From: marianne leslie
To: [Robin Proebsting](#)
Cc: [Marianne Leslie](#)
Subject: File No. SUB19-002, B&G Club proposed development
Date: Wednesday, May 8, 2019 4:32:00 PM

PRELIMINARY UTILITY PLAN
2825 W MERCER WAY
 PRELIMINARY PLAT
 PARCEL #2174502425
 CITY OF MERCER ISLAND WASHINGTON

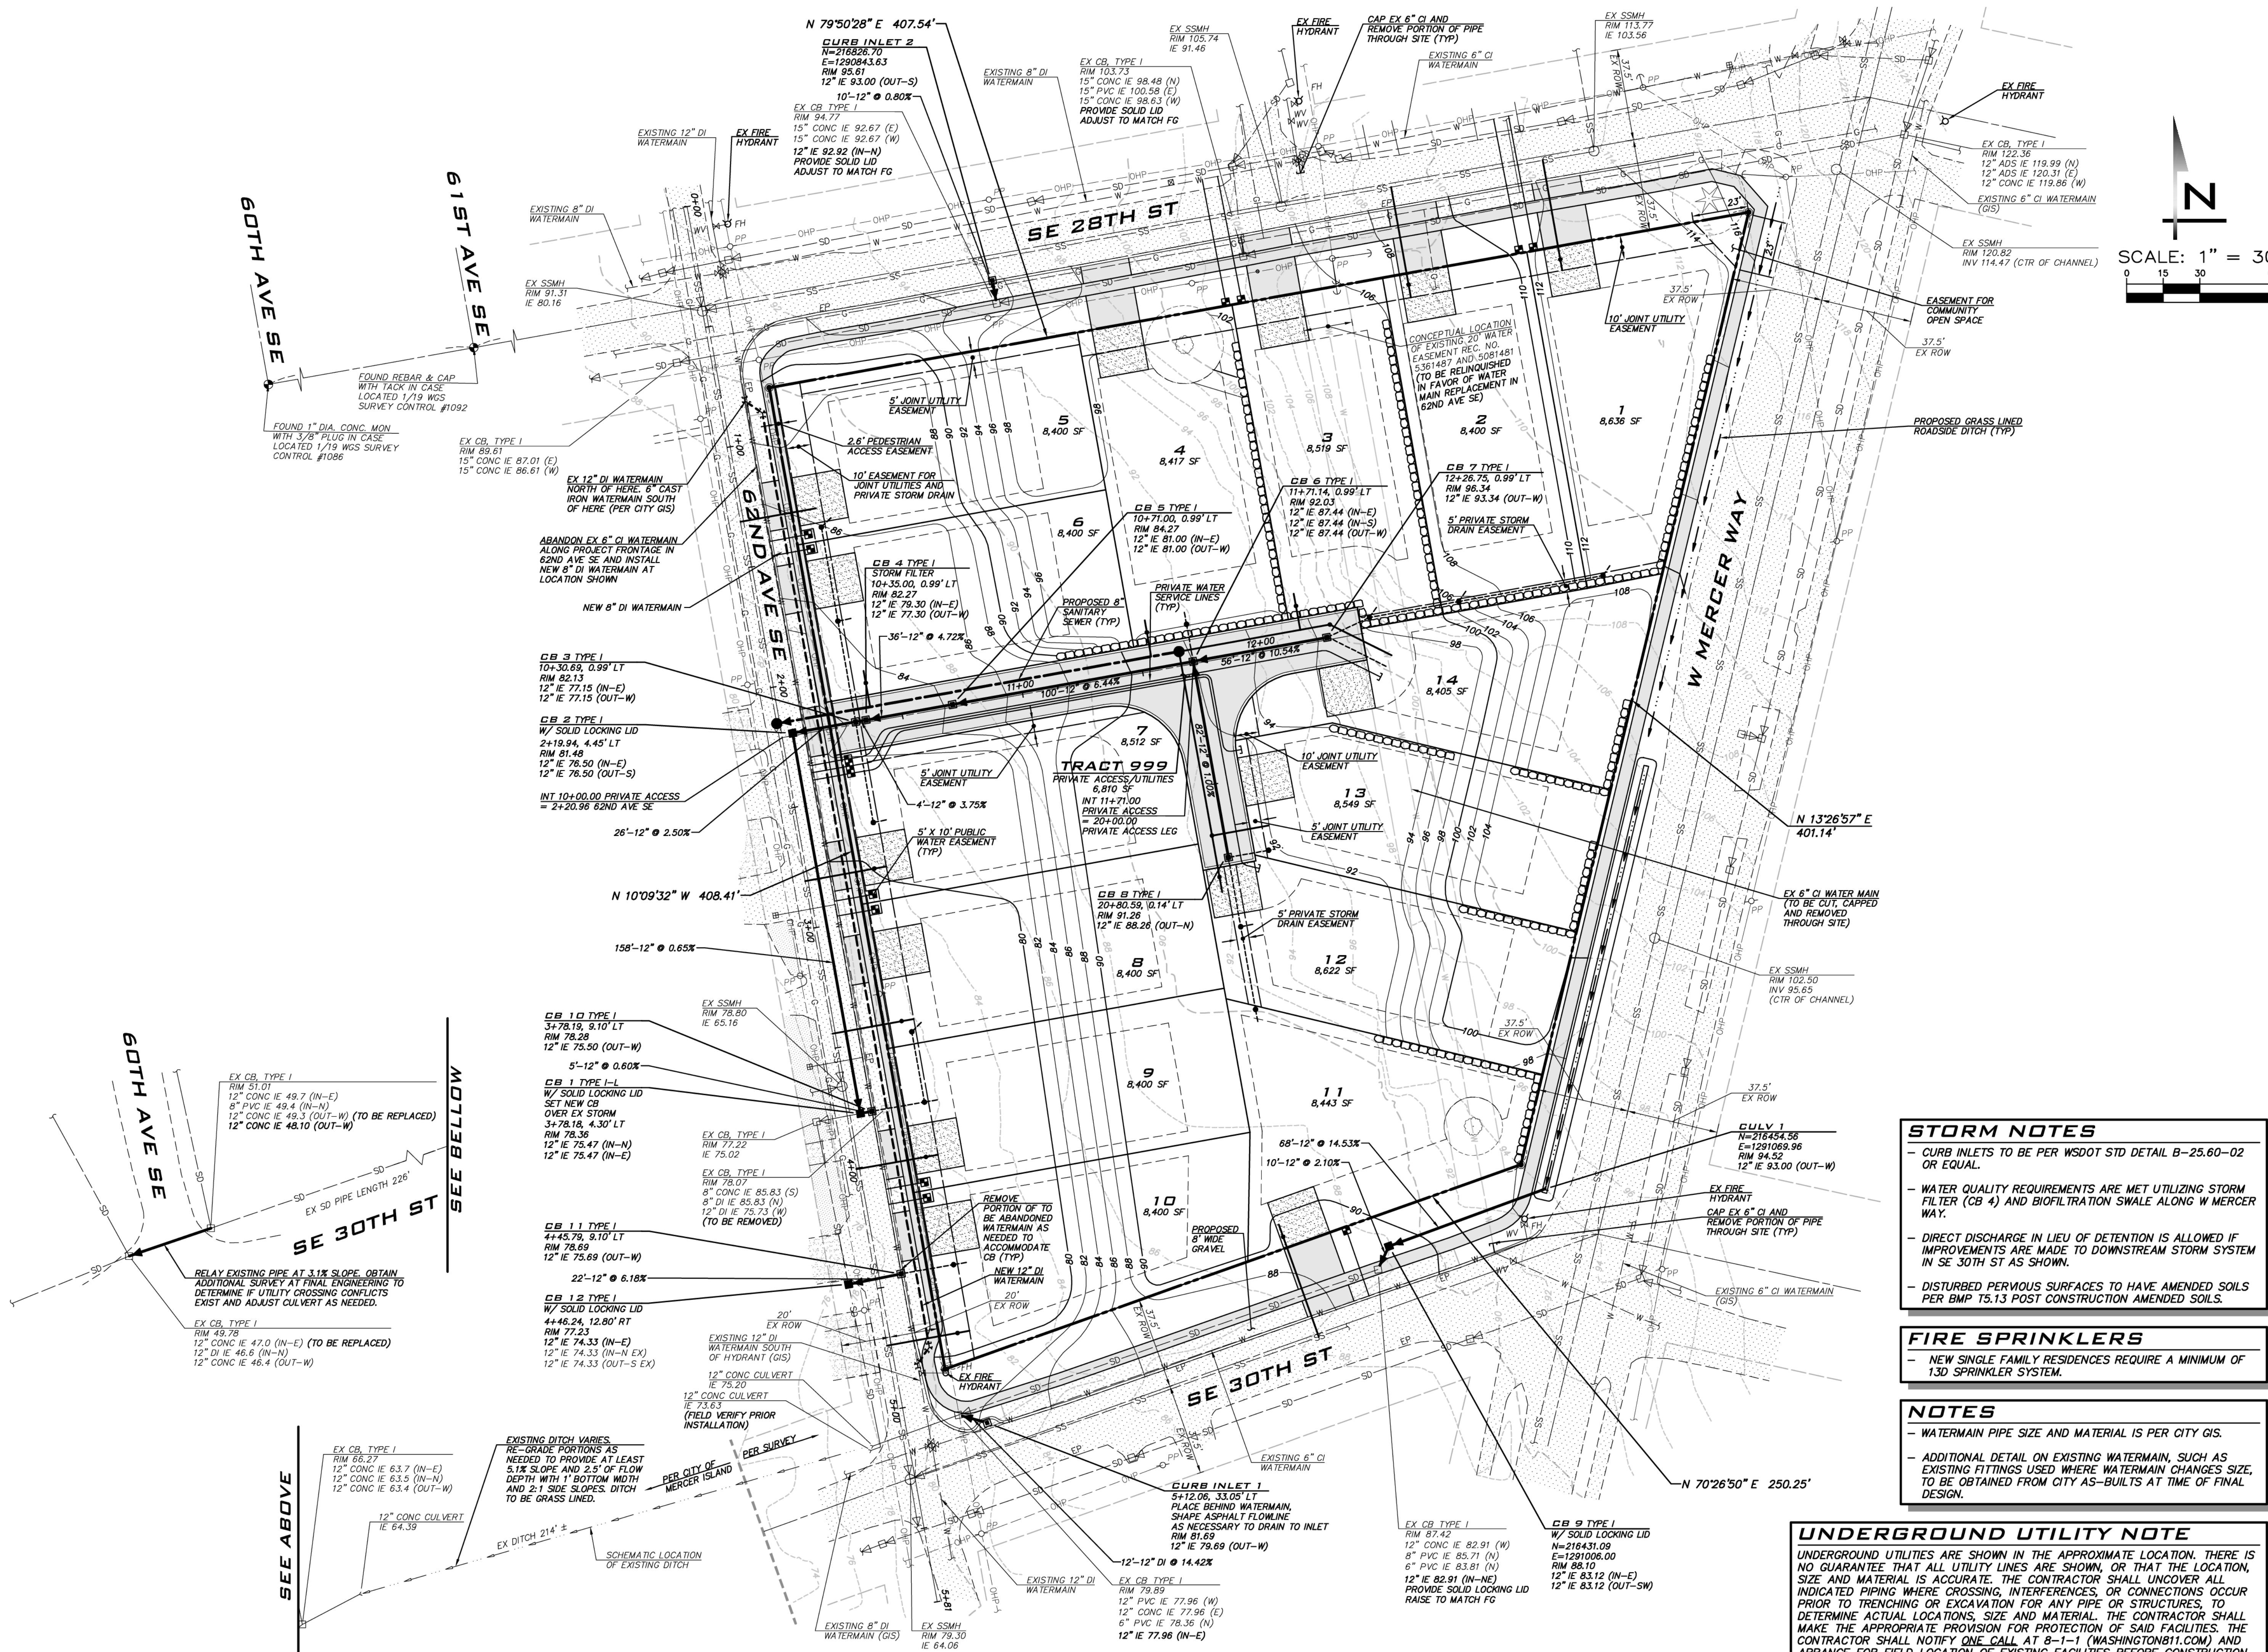
6. This project is located just two blocks from the shores of Lake Washington. The high density of this subdivision should be required to have a water treatment system for all impervious surfaces (roofs, patios, driveways, roadway...) before the water connects to the existing downstream drainage system, which then flows into Lake Washington. These water treatment systems are a retention pond or vault, and is the current technology being used in cities nearby. If there is no community water treatment, will each home in the subdivision be required to have its own water treatment system before water is "dispersed" into the current downstream drainage, which eventually goes into Lake Washington?

**PRELIMINARY ROAD PLAN &
SECTIONS**

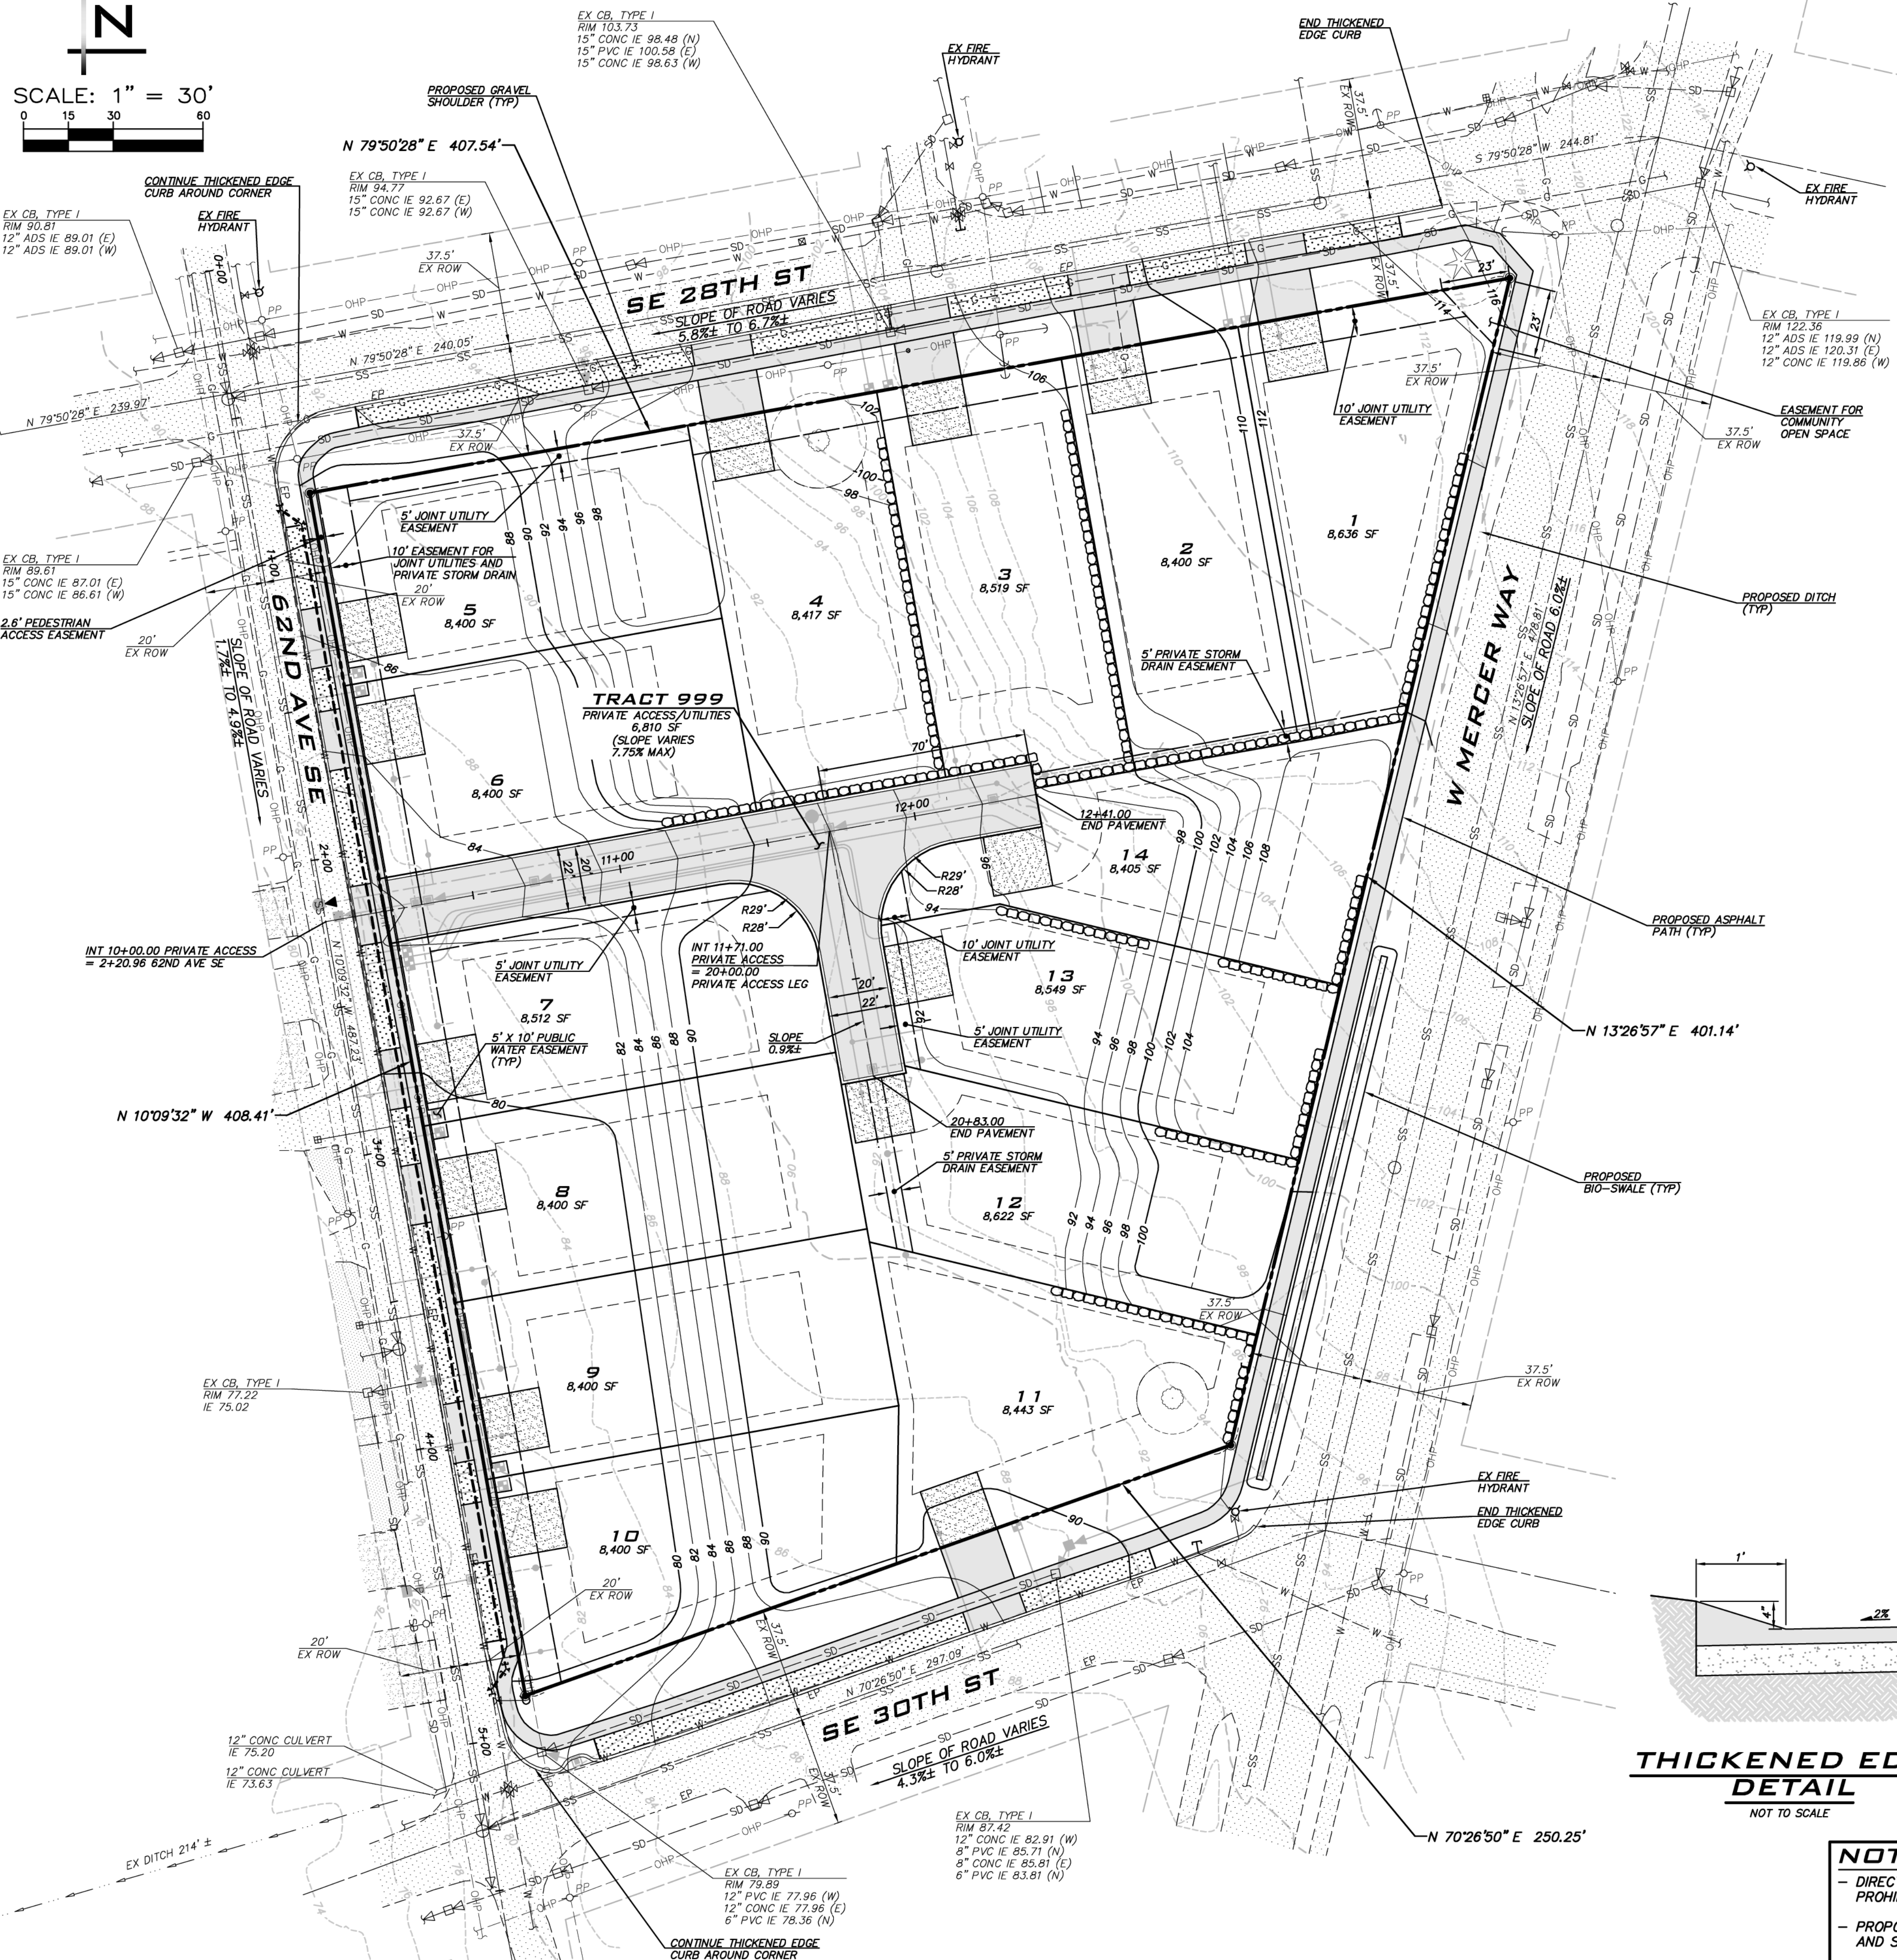
7. The detail for the proposed street entering the subdivision from 62nd Ave SE appears to not have any turnaround for emergency vehicles. I believe there is always a requirement for new developments that allow enough room for fire trucks and other emergency vehicles to enter and turnaround. Shouldn't this be a requirement for this subdivision?

service people park when they visit these homes? There appears to be no additional parking on the proposed drawings, and it is unclear how wide the new street is going into the subdivision. Will the street be wide enough for two cars to pass, and have parking on the street as well? Given what I have seen on the drawings, one can only conclude that all these additional vehicles will park on the streets surrounding this new development. SE 28th, 62nd Ave SE, SE 30th, and West Mercer Way. With additional cars, comes additional pollutants, which will eventually make their way into Lake Washington just two blocks away.
